CITY OF PORTLAND, MAINE

December 10, 2015

Project Name: **Conversion of Parish House into 5 residential units**
Project ID: #2015-131
Address: 26-32 Thomas Street CBL: 62 E Parcel 5
Applicant: Professor Frank Monsour, 32 Thomas Street, LLC
Planner: Jean Fraser

Proposed Site Plan and Preliminary Landscape Plan

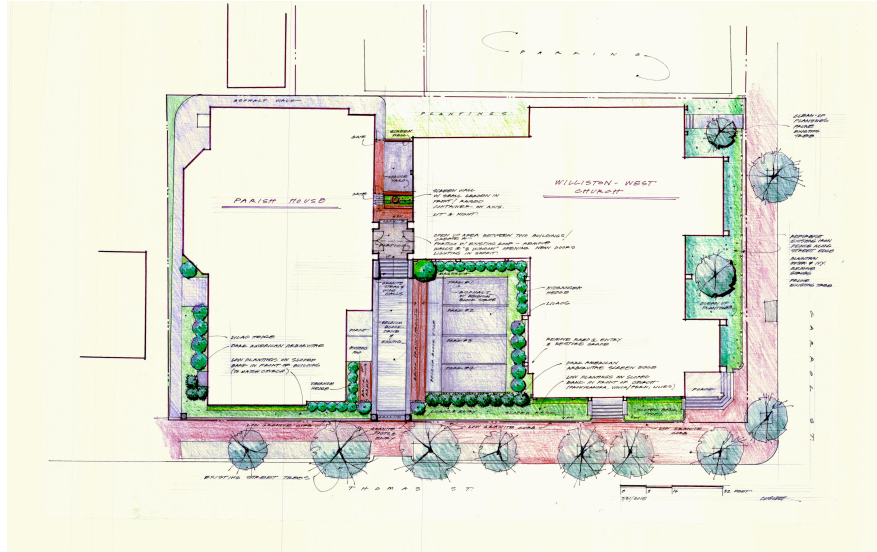
- ii. That the applicant shall revise and submit the plans to show the final CMP connection and underground service to the Parish House, to show that all the existing overhead lines on the site will be removed, and to clarify regarding snow removal, for review and approval by the Planning Authority and the Department of Public Works prior to the issuance of a building permit; and

- iii. That the applicant shall submit a plan showing the design and location of a bicycle rack to accommodate two bicycles, meeting the specifications in the City's Technical Manual, for review and approval by the Planning Authority and Historic Preservation Program Manager prior to the issuance of a building permit; and

- iv. That the applicant shall submit a revised plan to address the comments of the Traffic Engineering Reviewer Tom Errico dated 12.4.2015 regarding the sidewalk (crosswalk) ramps, and slopes within the relocated sidewalk apron, for review and approval by the Planning Authority prior to the issuance of a building permit; and

- v. That the applicant shall plant a street tree in the existing empty tree well in the Carroll Street ROW instead of filling the tree well in with brick; the size and species of the new street tree to be agreed with the City Arborist and it shall be planted prior to the issuance of a Certificate of Occupancy; and

- vi. That the applicant shall submit a revised on-street parking layout that takes account of the revised curb cut for review and approval by the Planning Authority prior to the issuance of a Certificate of Occupancy. It should be noted that any changes to on-street parking will require City Council action prior to the issuance of a Certificate of Occupancy, and the applicant would be required to assist in preparing council meeting materials; and

* In addition to providing detectible warning panels on the sidewalk ramps, the applicant should replace the brick material to meet City standards.

* The site plan notes that the driveway will have a cross-slope of 5%. The plans should be revised so that a 2% cross-slope is provided along the accessible pedestrian route along the sidewalk.
